Recommendation Report for Planning Permission for Works or Extension to a Dwelling

REF NO: FG/95/18/HH

LOCATION: 25 South Drive
Ferring
BN12 5QU

PROPOSAL: Two storey front extension, side/front first floor extension & replacement garage.

Drawing title:	Proposed Extensions and Alterations		
Date:	April 2018	Scales:	As shown
Paper size:	A1	Dwg No:	AR-102-203/B

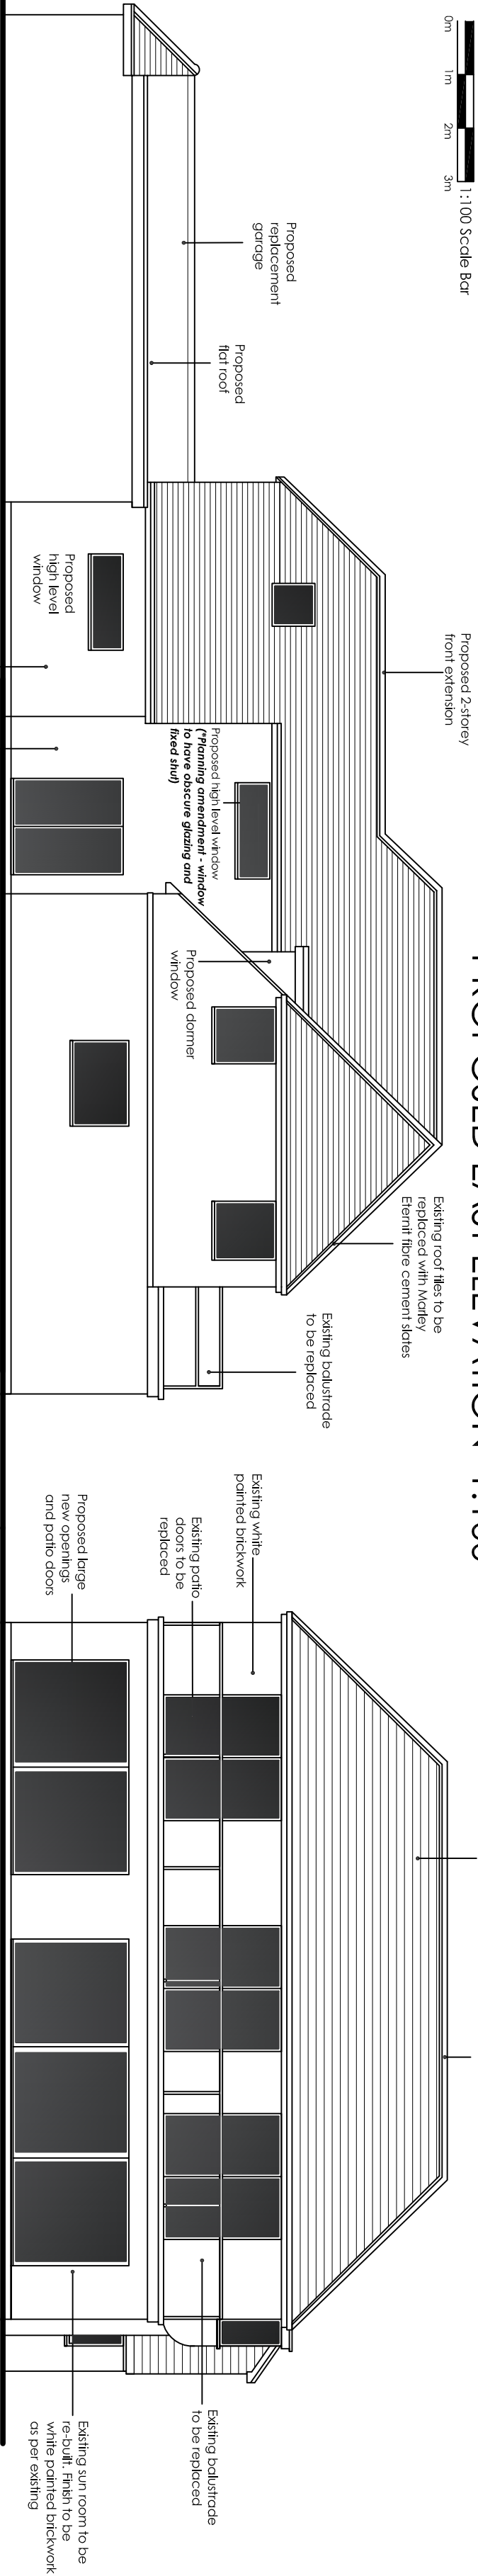
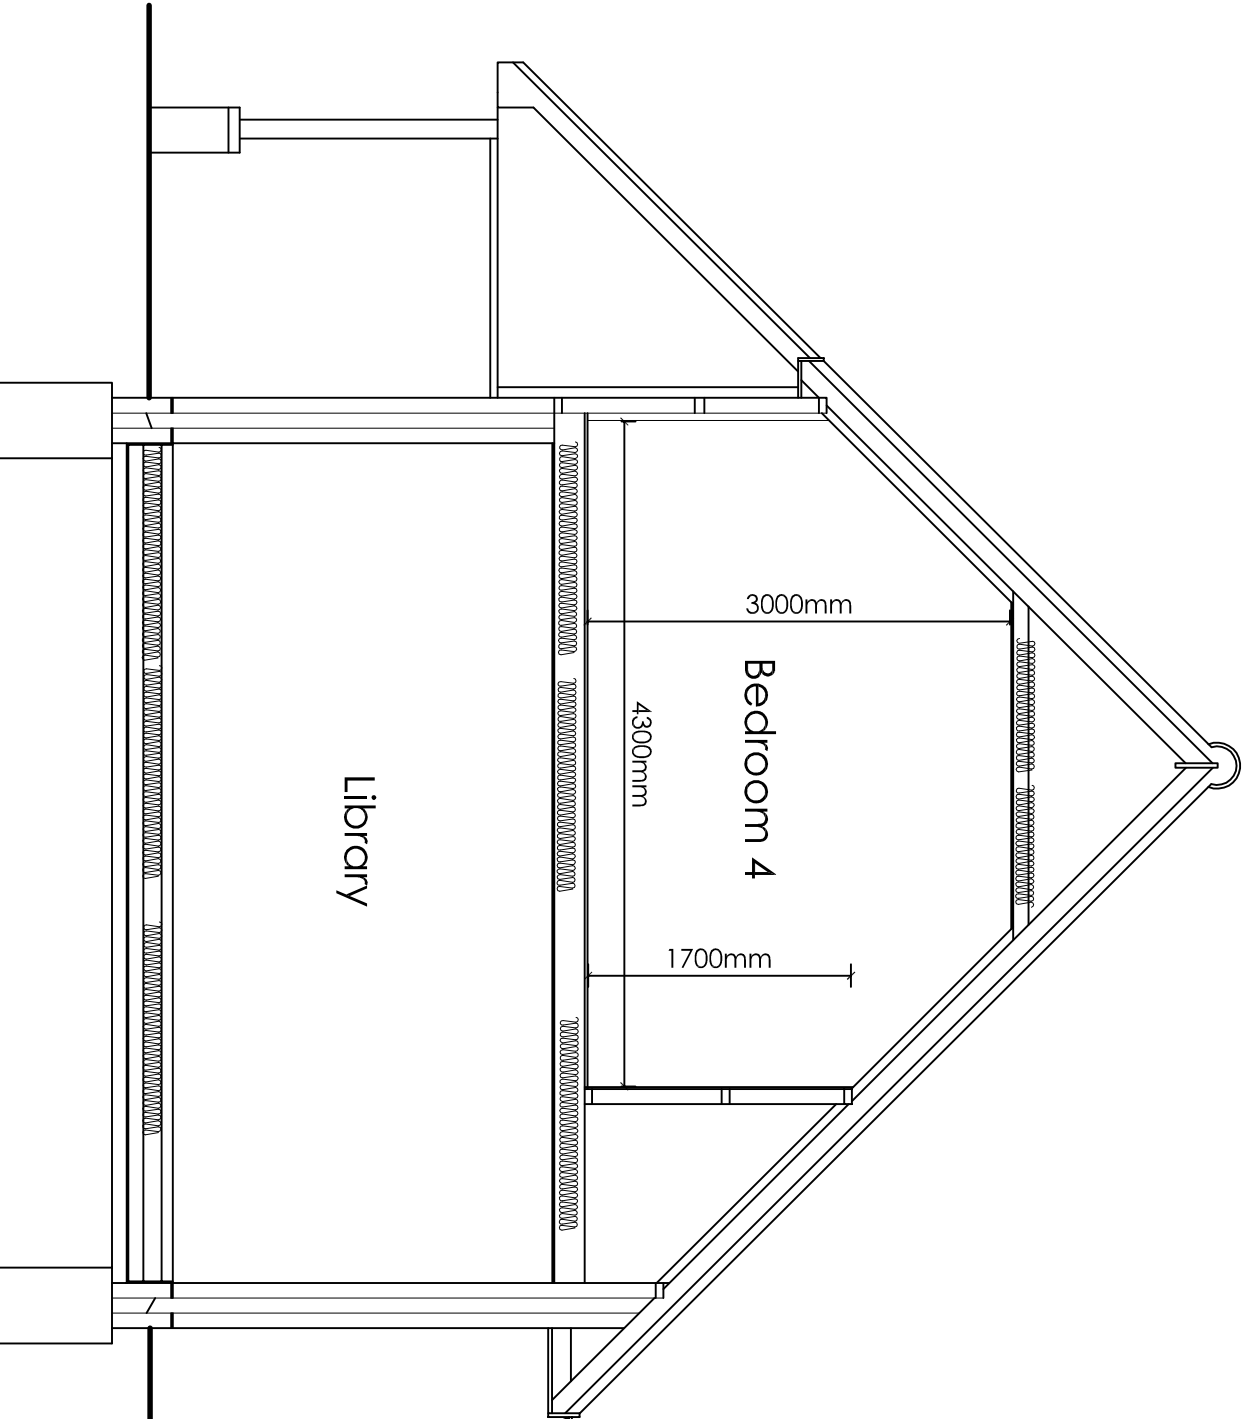
Object to the high level window to bedroom 4 on the west elevation:

- This window will overlook our property as it will have a line of sight over the wall and directly into our kitchen. This will lead to loss of privacy.

-No further objection if the window was obscured and non-opening.

Objection from number 27 has been raised regarding potential overlooking from the proposed high level window to bedroom 4 on the west elevation whereby:

'This window will overlook our property as it will have a line of sight over the wall and directly into our kitchen. This will lead to loss of privacy.'

'No further objection if the window was obscured and non-opening'

Amended plans have been received stating that the high level window (not the rooflight) serving bedroom 4, as aforementioned, would be obscure glazed and fixed shut. Therefore Officers consider that no overlooking would be able to occur from this window and as such this would deal appropriately with the neighbours objection.

Reason: In the interests of amenity to achieve a reasonable visual quality in the buildings in accordance with policies D DM1 and D DM4 of the Arun Local Plan.
- 4 The high level window in the western elevation, serving bedroom 4, shall at all times be glazed

with obscured glass and fixed to be permanently non-opening as shown on Drawing number AR-102-203/B.
